MMC Visitor Garage and East Tower Project - Initial Traffic Comments

Hi Jean – the following outlines my initial comments as it relates to the above noted project. Please note that the comments do not include a review of the Congress Street Traffic Control Plan.

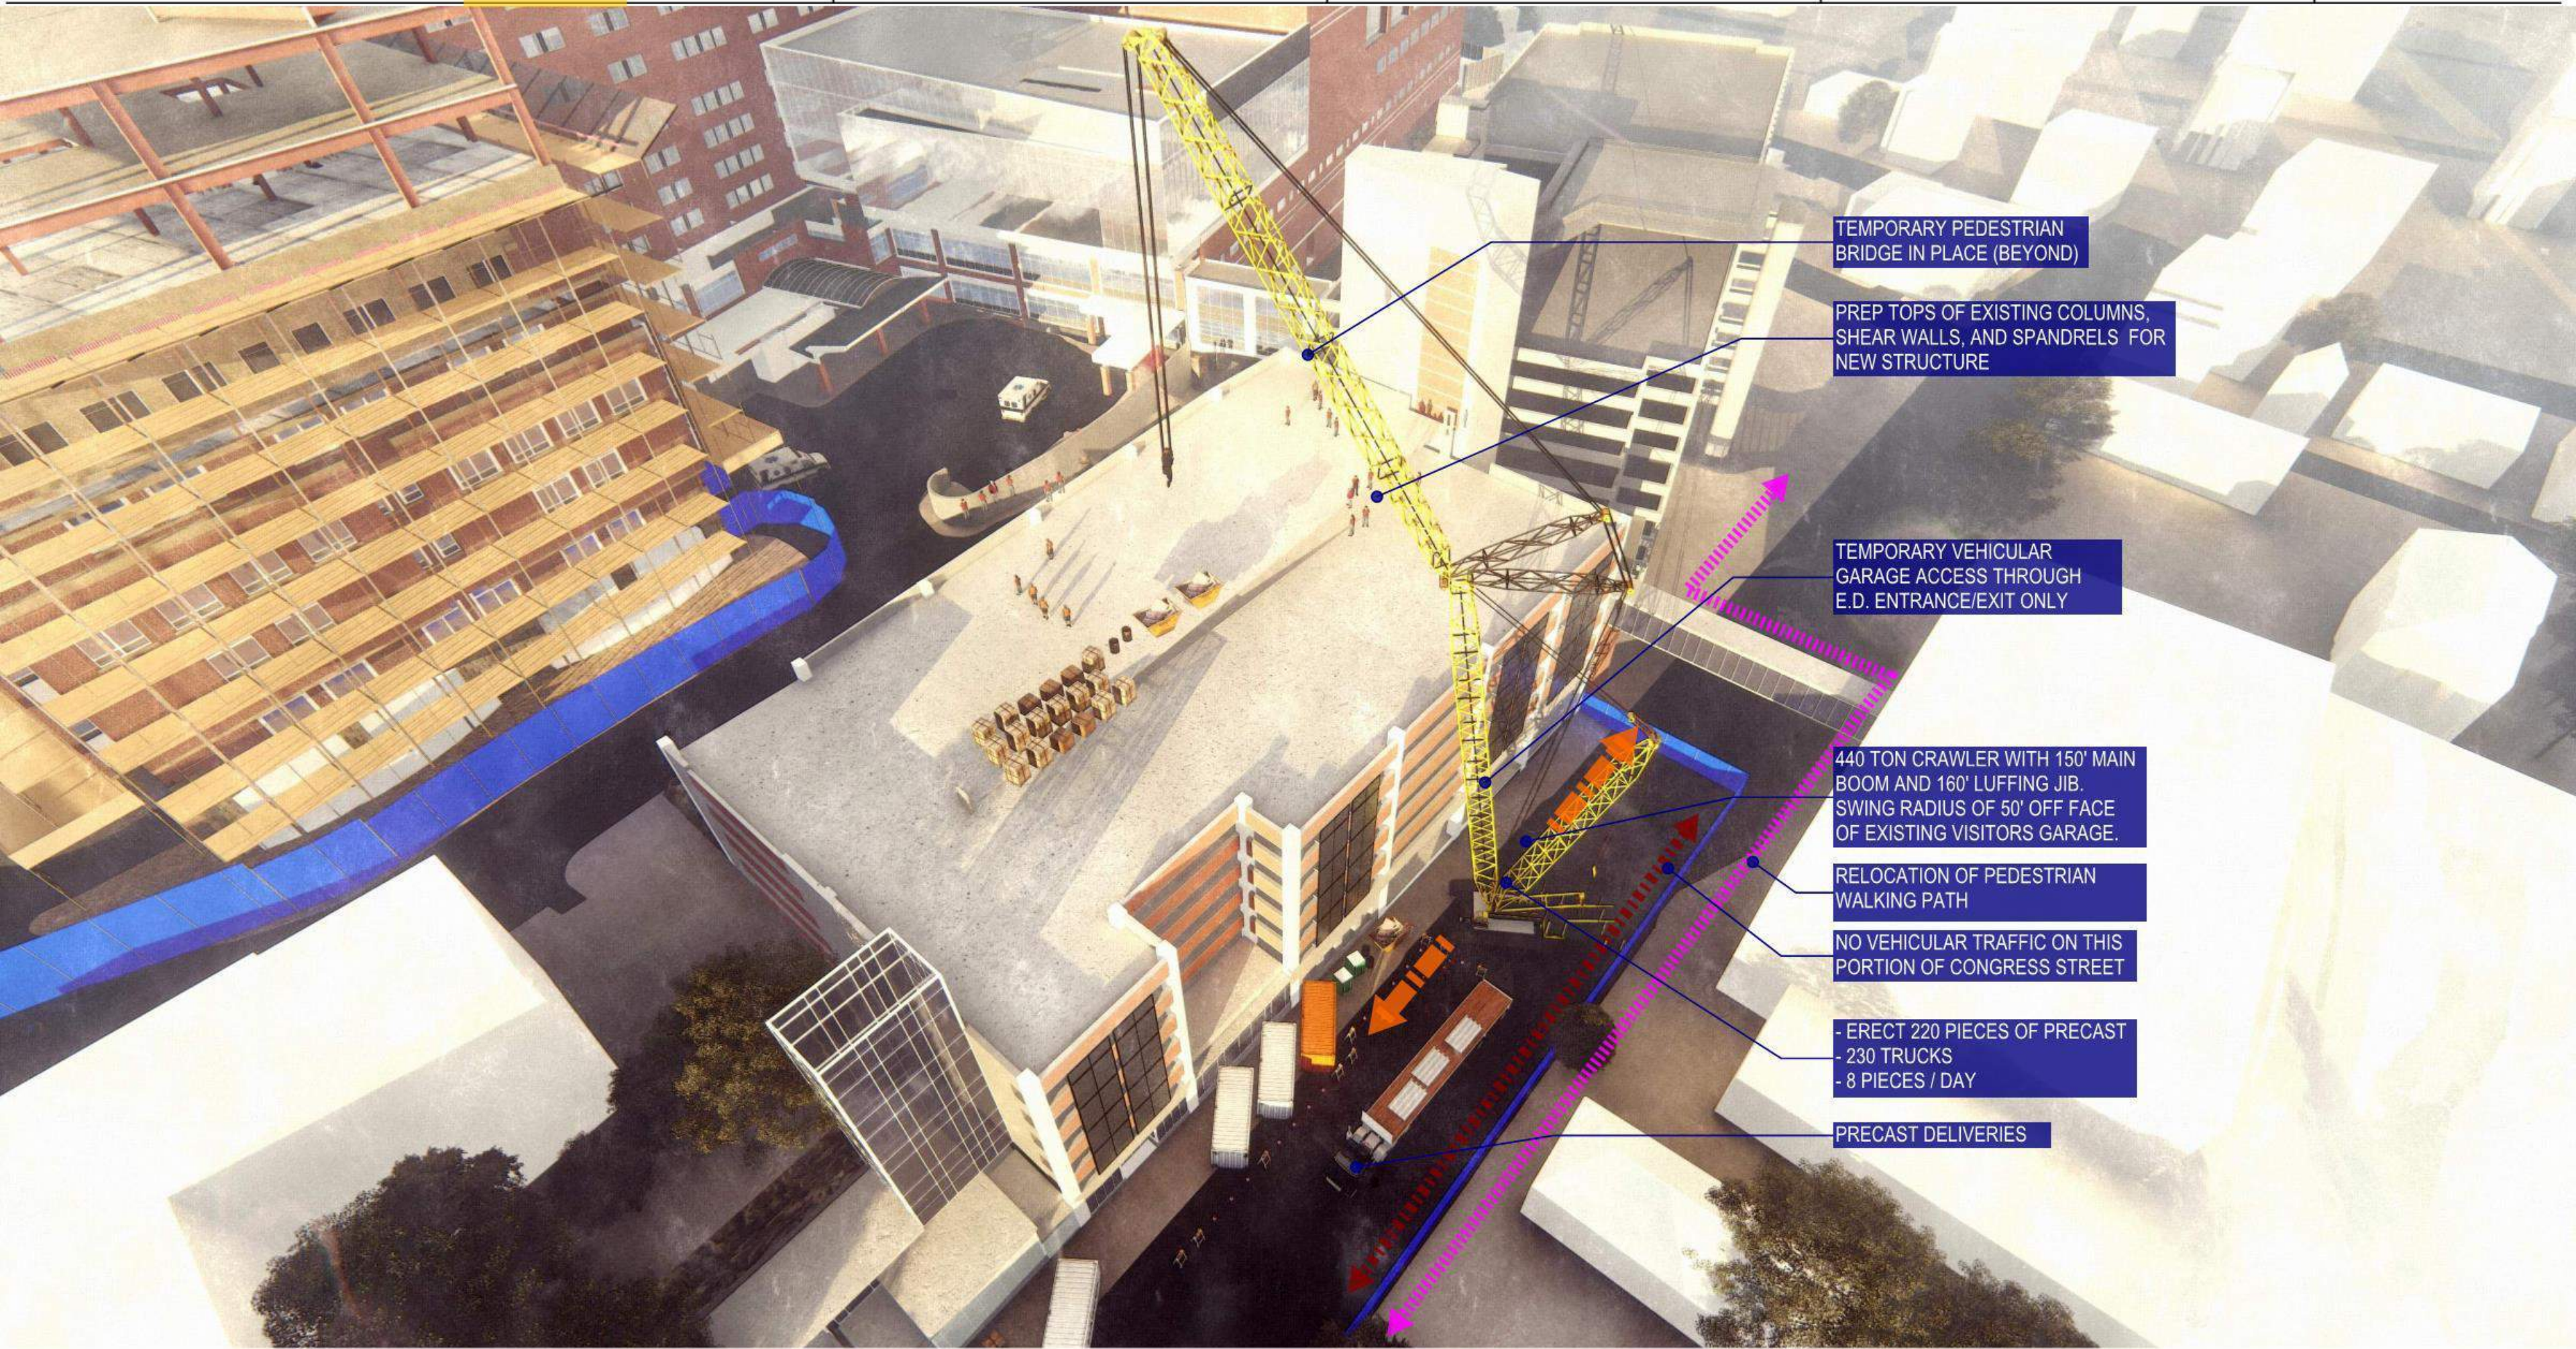
- During the construction of the Visitor parking garage, the top two floors of the existing garage will be taken out of service. The applicant should provide parking management details addressing the loss of the noted parking spaces.

[ East Towers ] Logistics Plans and Studies

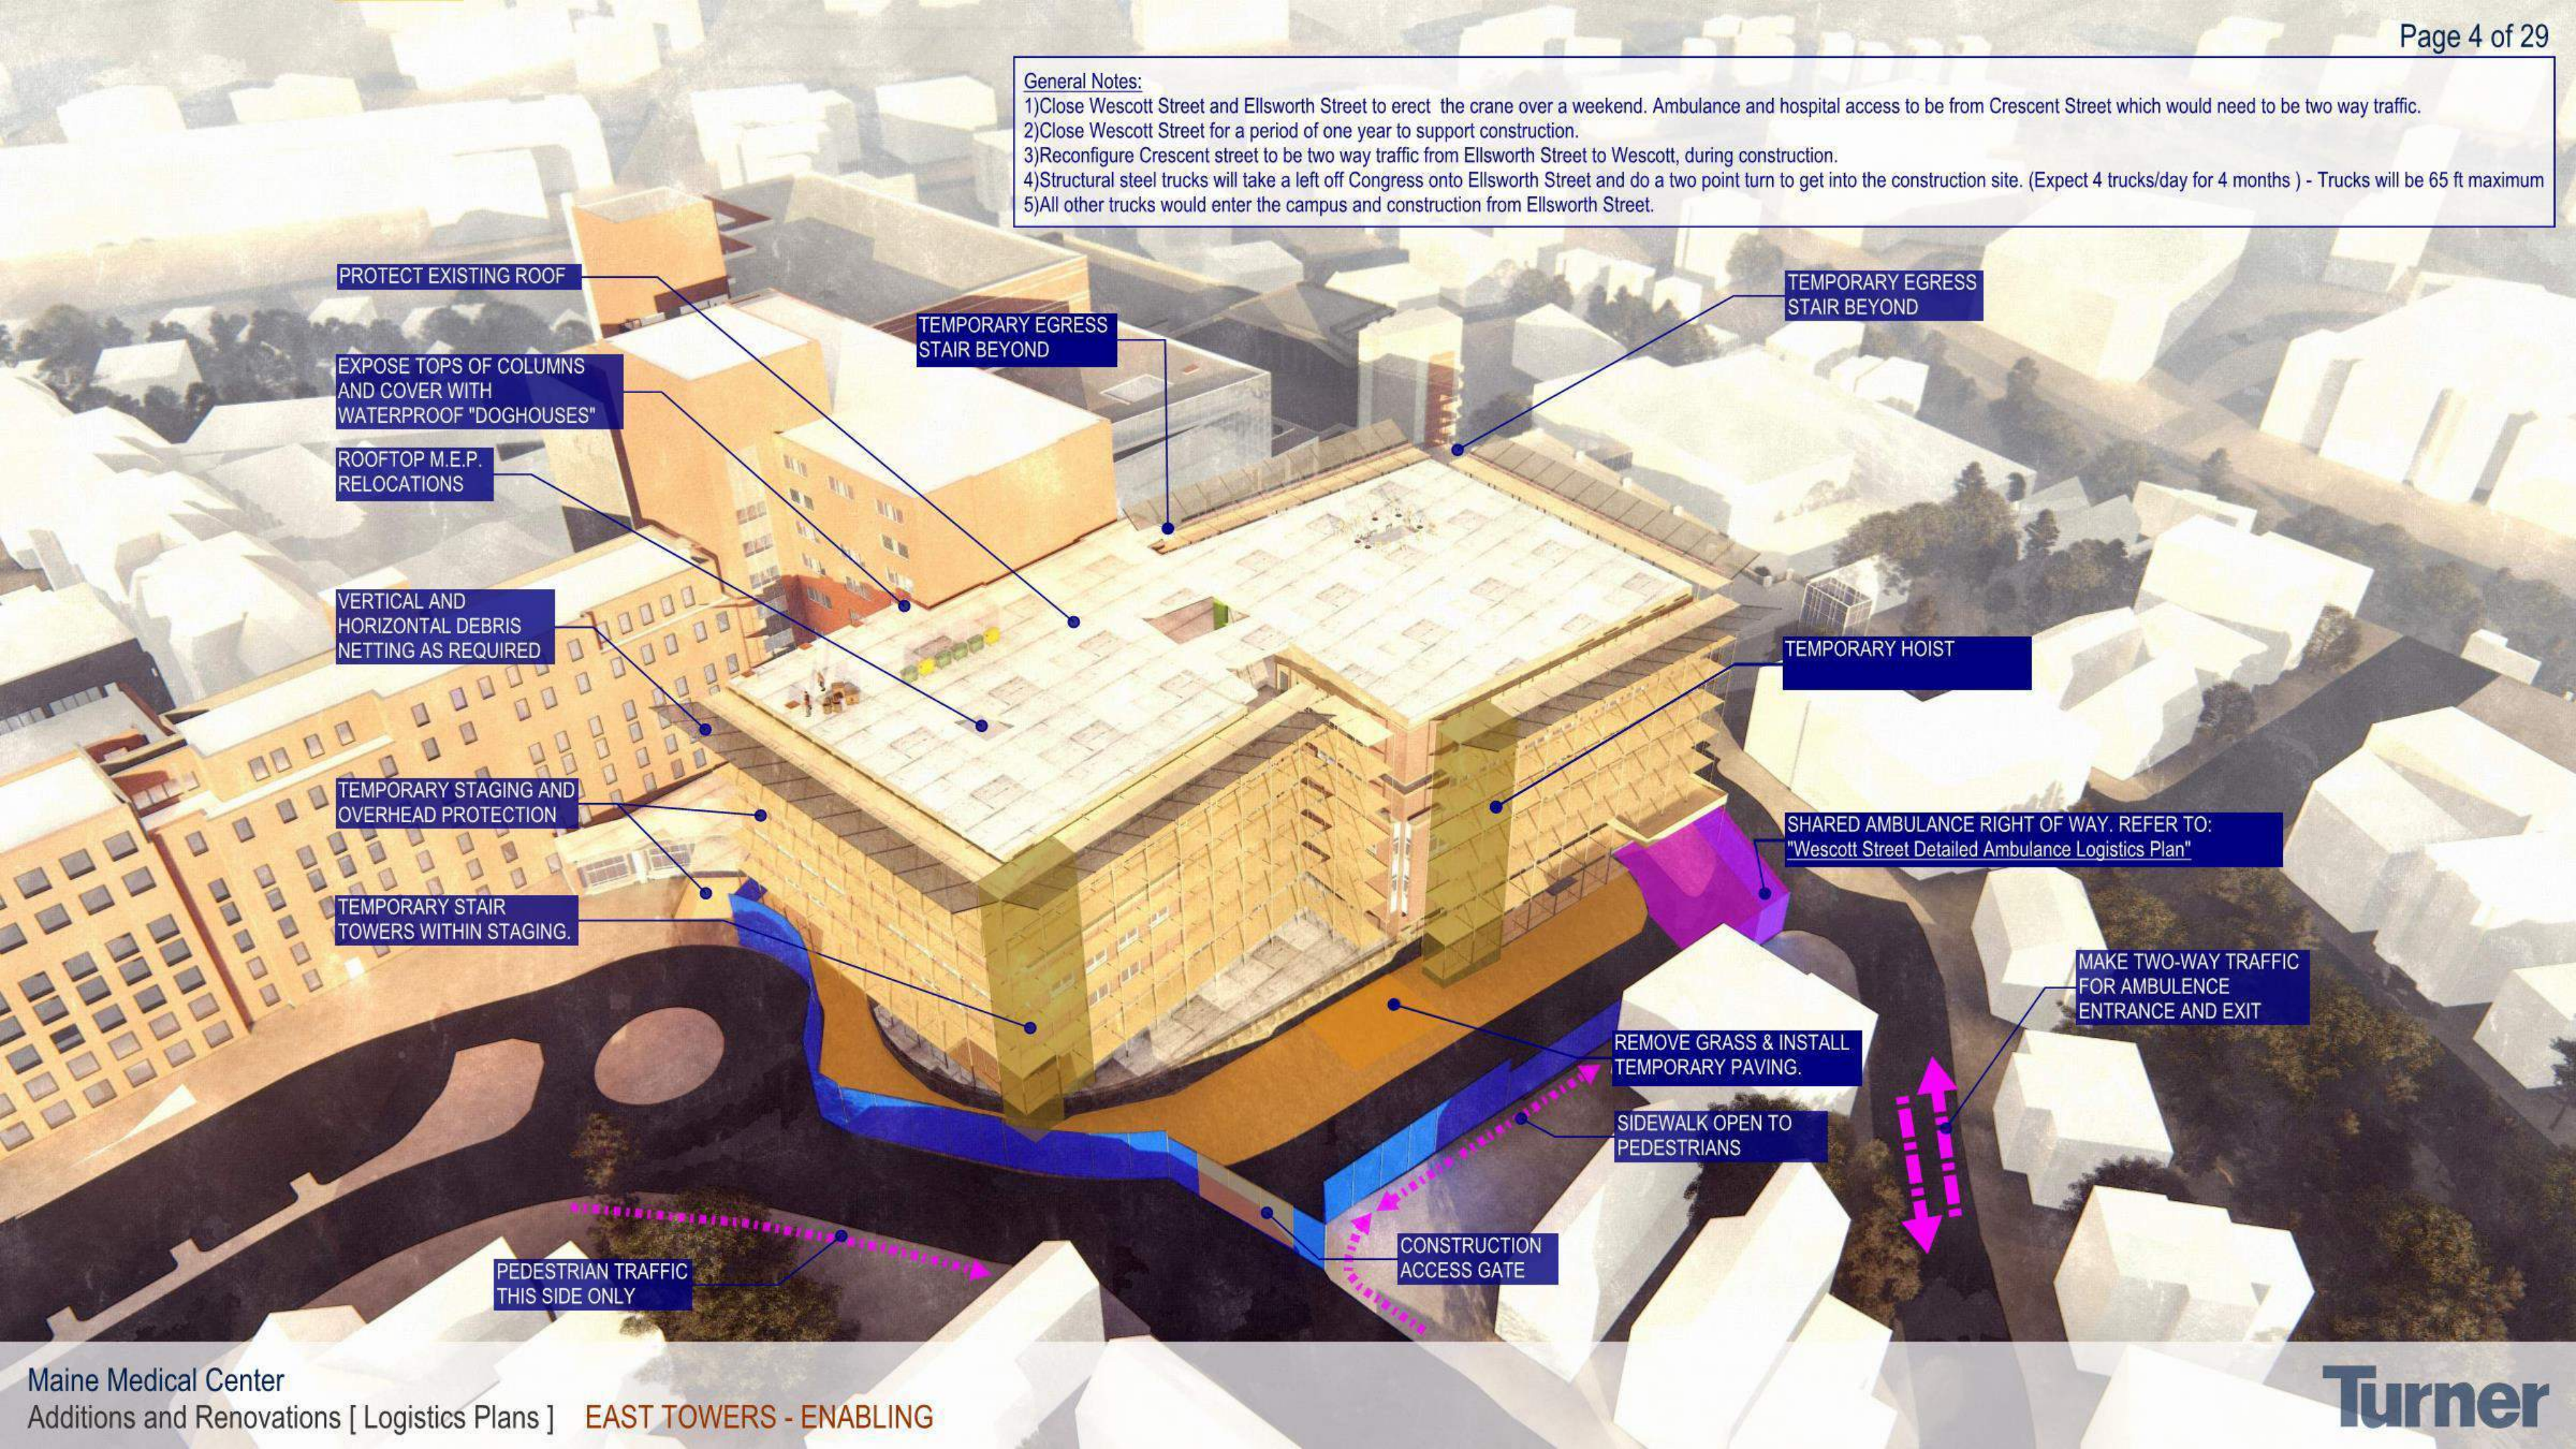
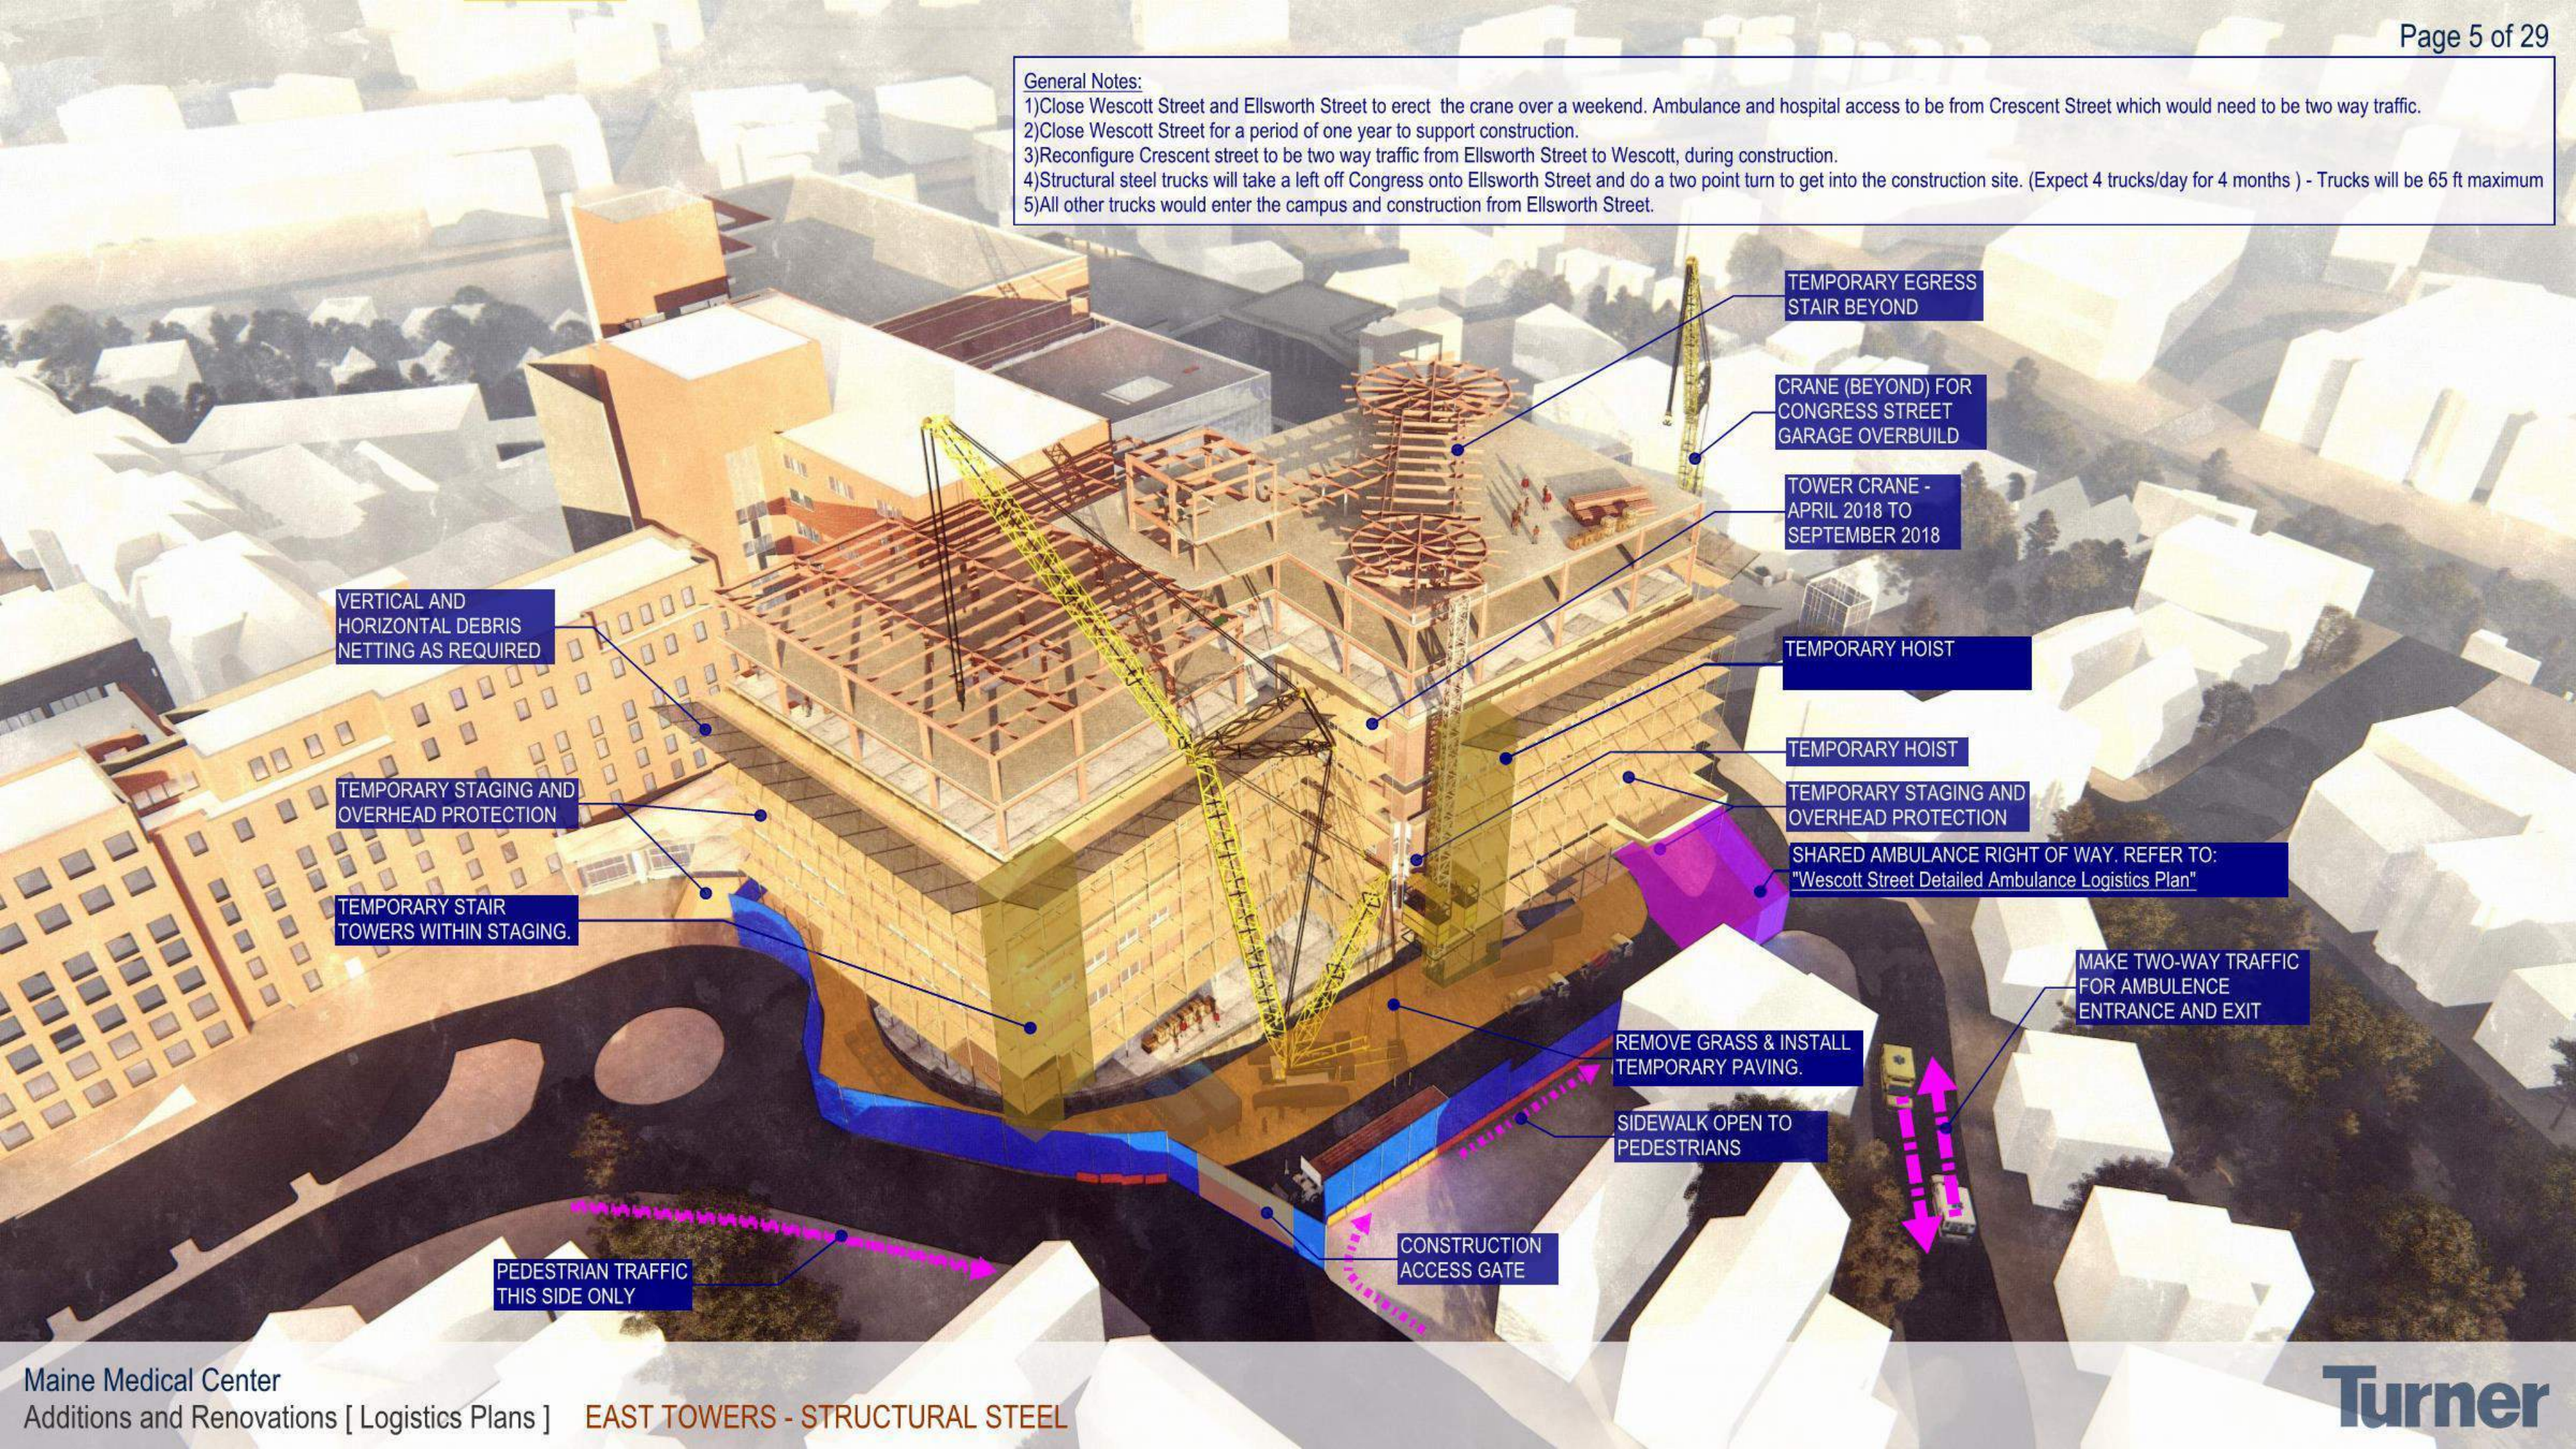
- The following are initial East Tower Traffic Control Plan comments:
 - The City does not support the conversion of Ellsworth Street to two-way flow between Congress Street and Crescent Street. The applicant has noted this to be acceptable. The plans should be revised to reflect this change.

- It is unclear if the bump out at the Crescent Street/Wescott Street intersection is to be removed. If it is to remain, vehicle turning templates should be provided for review and approval.
